Application No: FG/58/14/PL

Recommendation Report for Planning Permission

LOCATION: Hangleton Farm Equestrian Centre
Hangleton Lane
Ferring

PROPOSAL: Demolition of existing barn and erection of new storage barn.

1:100 MARCH 2014 8059/2C

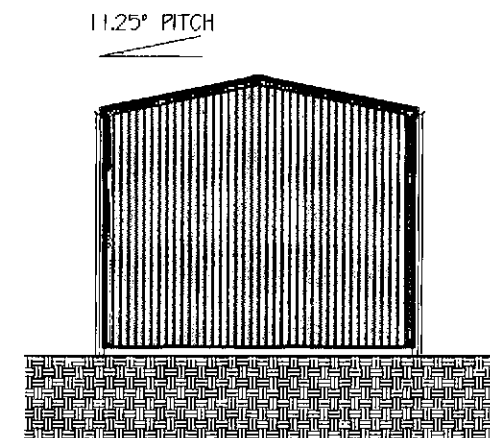
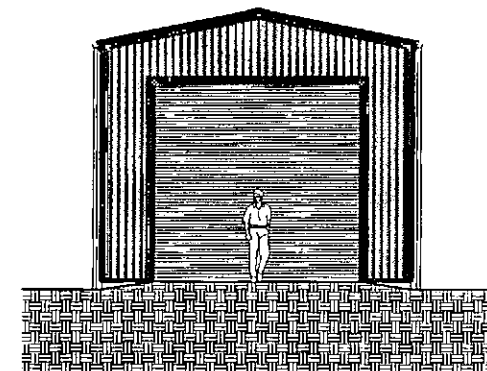
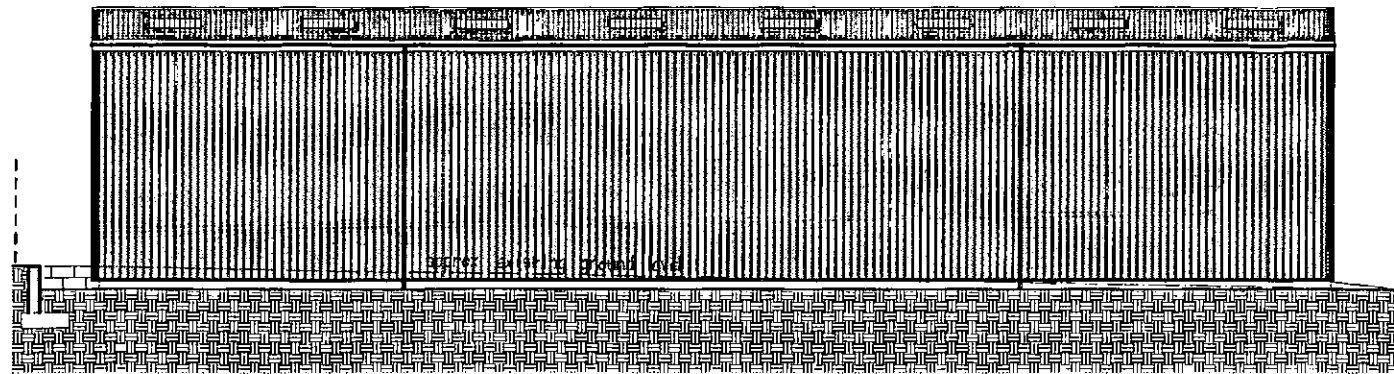
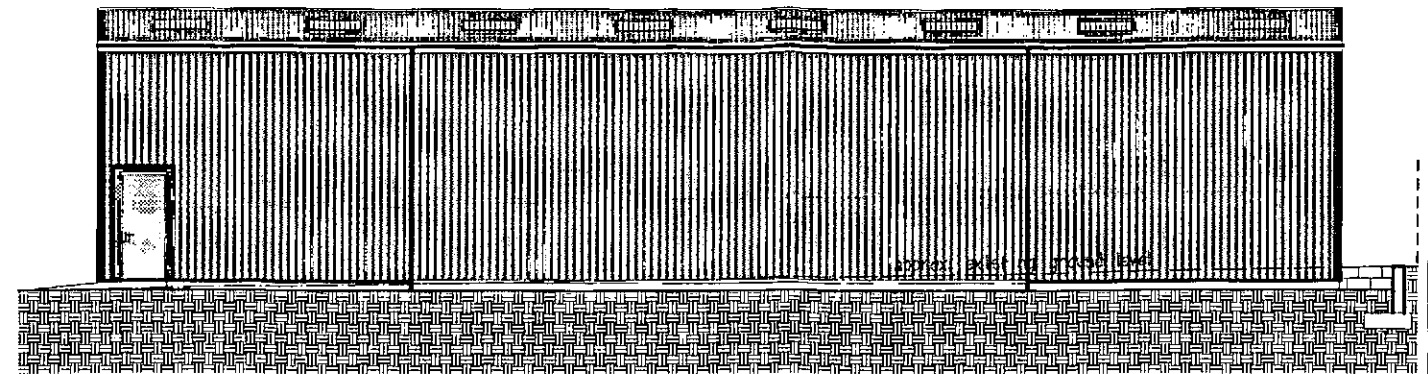
Reason for Update/Changes: The agent has reduced the height of the building by 0.5m and substitute plans have been submitted in this regard.

Objection - The proposed size of the barn is enormous.

The proposed barn will be overbearing and out of keeping with the area and it will also be clearly visible from the National Park.

The height of the barn has been reduced by 1.3m. It would not be readily visible from outside the site given the presence of tree screening to the west and other structures within the equestrian complex. The colour and design of the building would be appropriate for this setting and the agent has confirmed that the primary purpose of the new barn is for the storage of hay and straw due to the inadequate amount of existing suitable storage space. It is essential to have a barn of the submitted size to store hay and straw and benefit from the economies of scale derived from large orders.
